**WRITTEN REPRESENTATIONS**

**ON BEHALF OF THE  
HISTORIC BUILDINGS AND MONUMENTS COMMISSION FOR ENGLAND  
(HISTORIC ENGLAND)**

**Highways England for an Order granting Development Consent for the  
A1 Birtley to Coal House Improvement Scheme, Tyne & Wear**

**PINS Reference No: TR010031**

Longbank Bridleway Underbridge
OS Grid Ref: 427169E, 557294N
STKEY 26280
Structure No. A1/440.80
AIP - Longbank Underpass
Ref SOR06

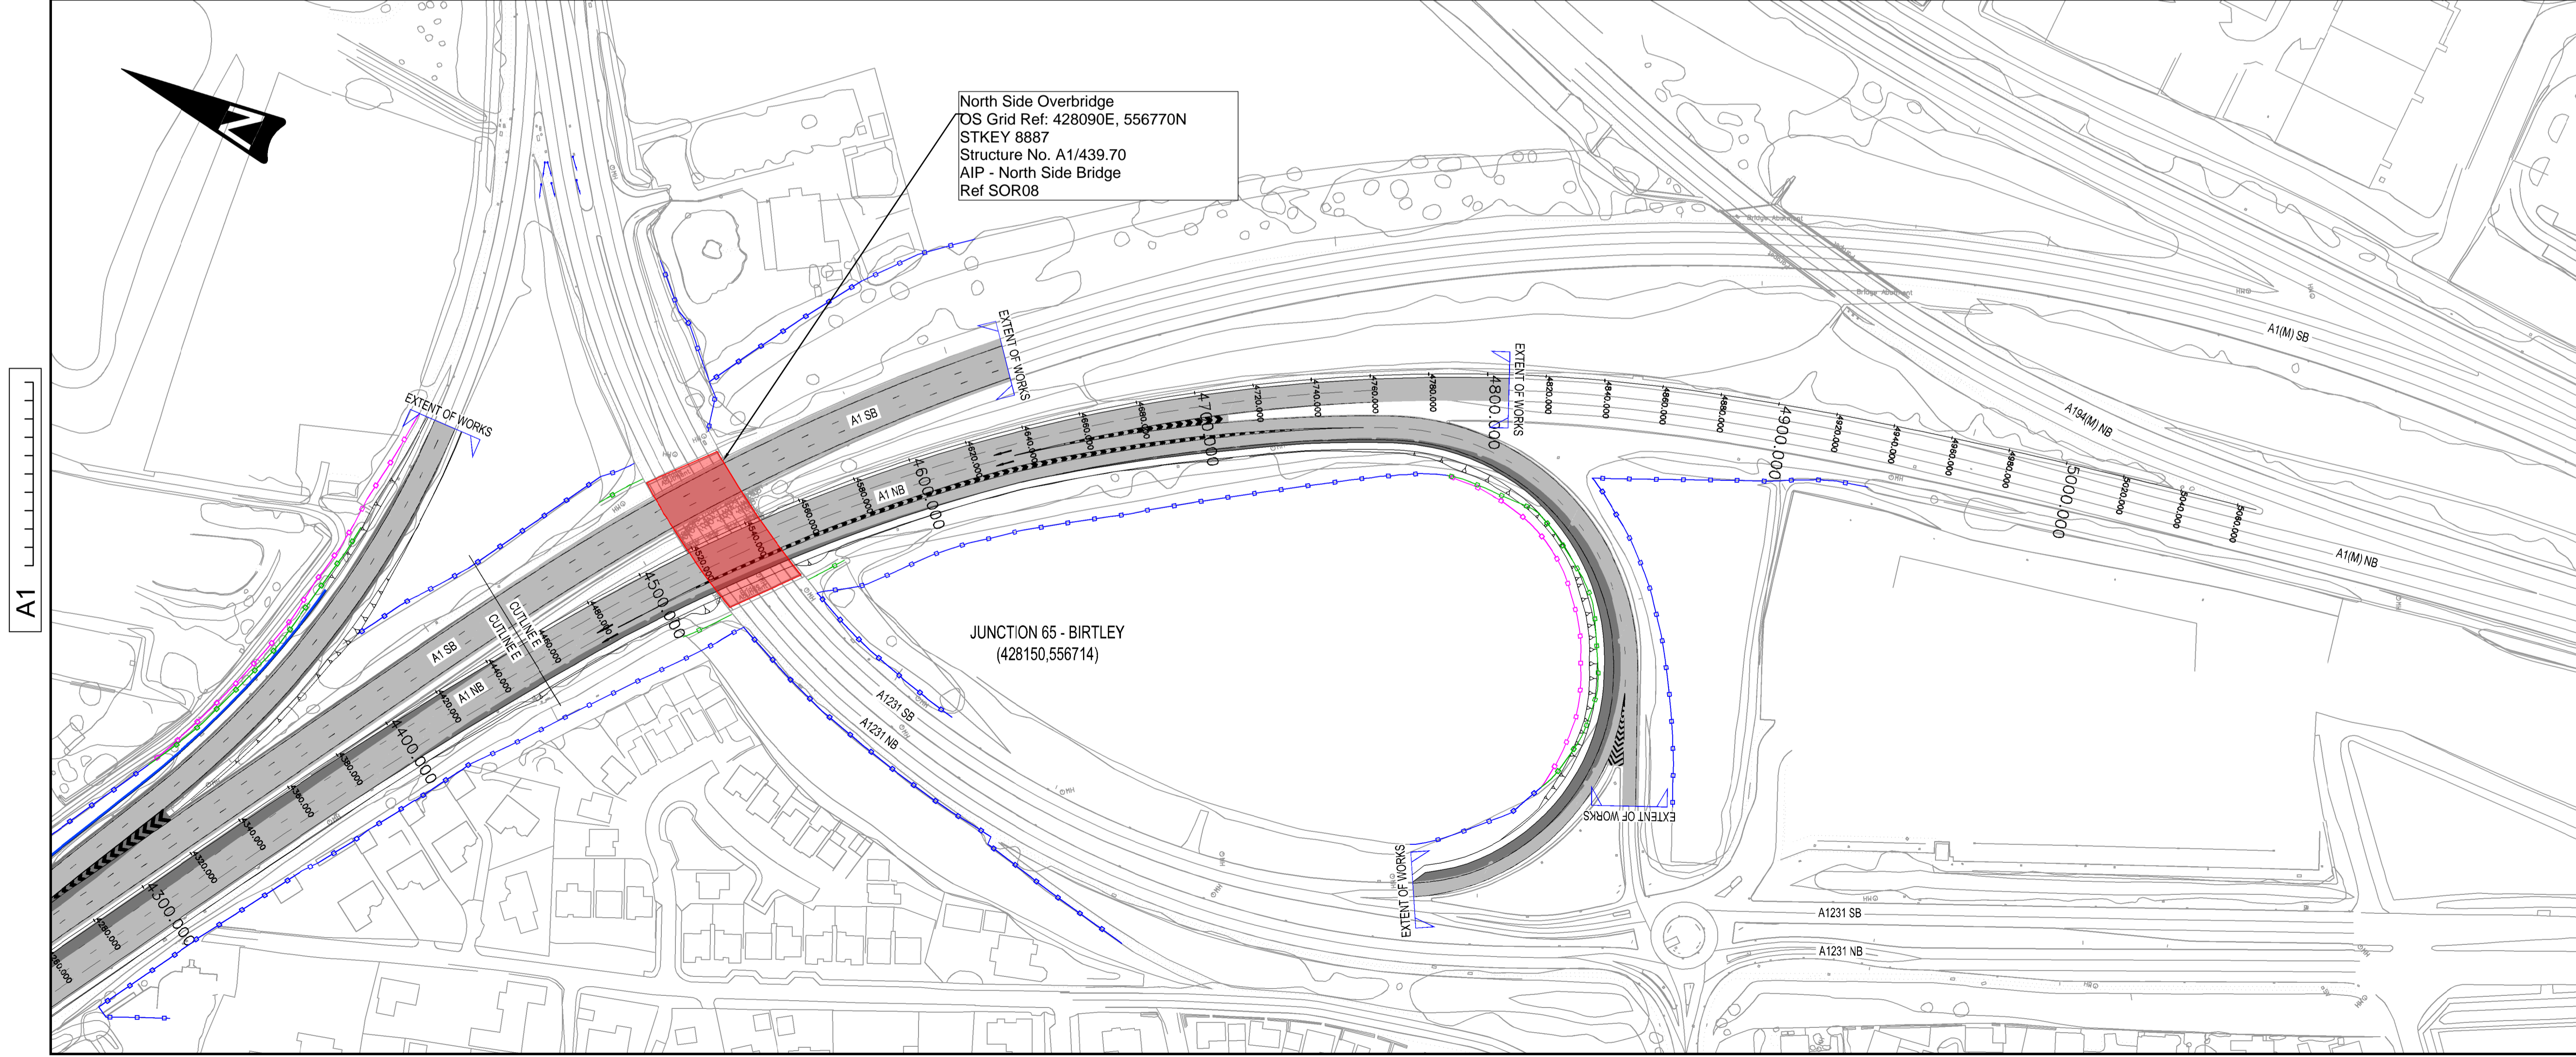
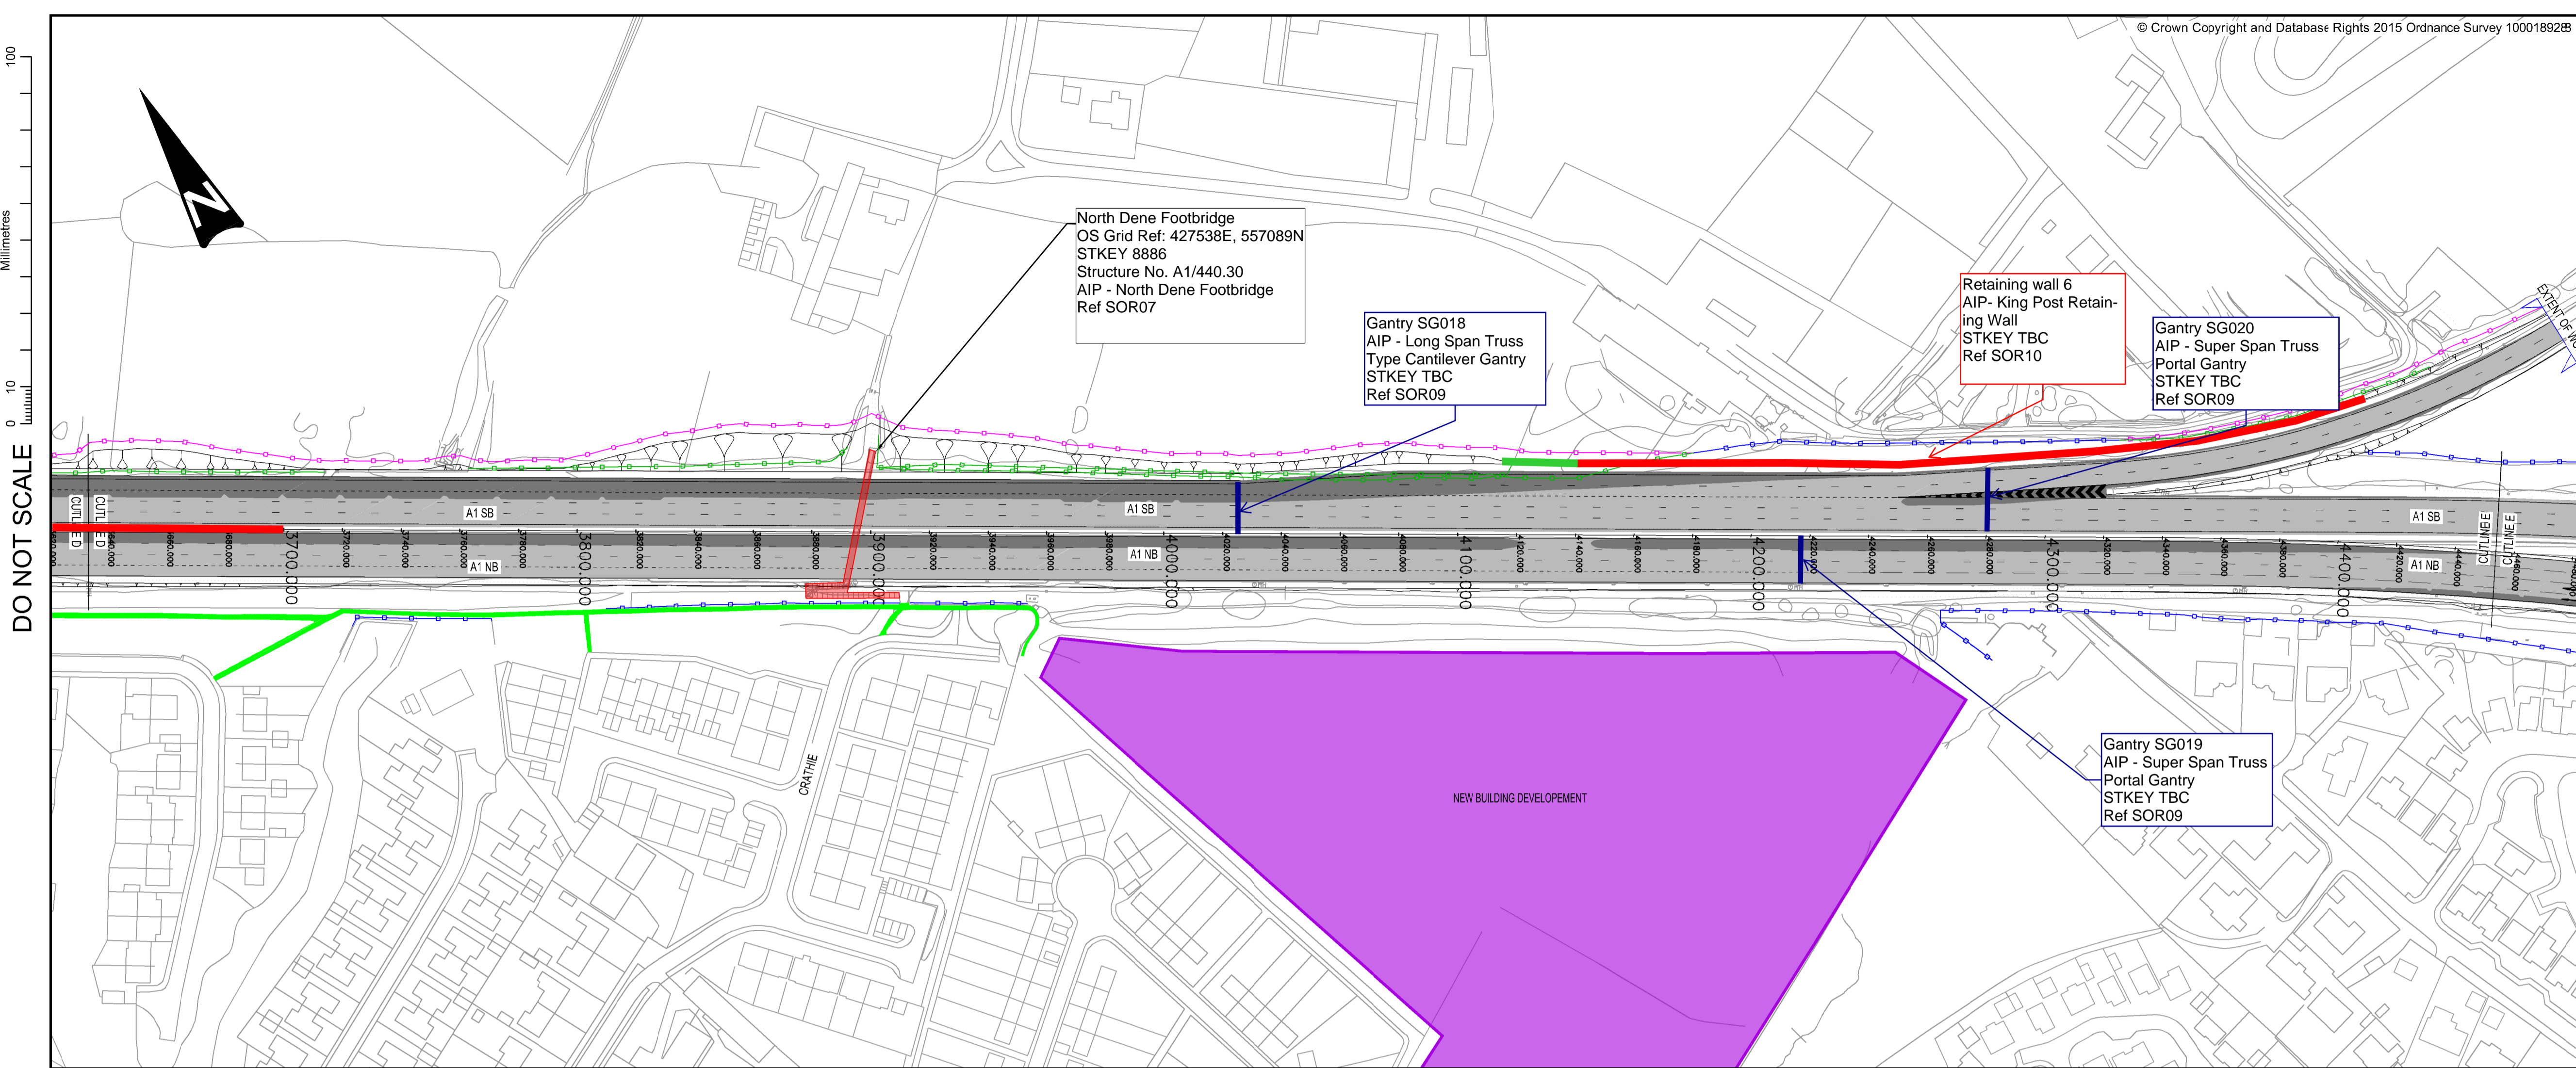
- 5.9 The proposed works will cause substantial harm (as per NPPF para 195) to a limited part of the scheduled monument. On the southbound side of the A1 it is proposed to extend to the north-east a bridge arrangement over the line of the monument. The scheme drawings (see TR010031/APP/2.7(J) in Section 2.7 of the ES) show an indicative length of new construction to be approximately 16.7m. The development will require the excavation of two construction trenches into which numerous piles will be drilled at 1m intervals. This will impact on extant revetment walls on either side of the trackbed, and may potentially damage buried remains such as evidence of rails, trackbed construction and associated features.

- 5.10 The ES currently assesses that this will be a “minor” magnitude of impact (ES 6.1 Cultural Heritage para 6.10.2) which Historic England contends is not accurate as there will be a permanent removal of this part of the monument in the area affected and therefore the impact will be ‘major’, i.e. there will be ‘substantial harm’ (as per NPPF para. 195) to this part of the monument. We do, however, concur that overall there will be a ‘moderate adverse significance of effect’ or in NPPF terms, a ‘less than substantial harm’ to the overall significance of the monument. This will therefore require a balancing of the harm against the perceived public benefits of the scheme by the ExA.
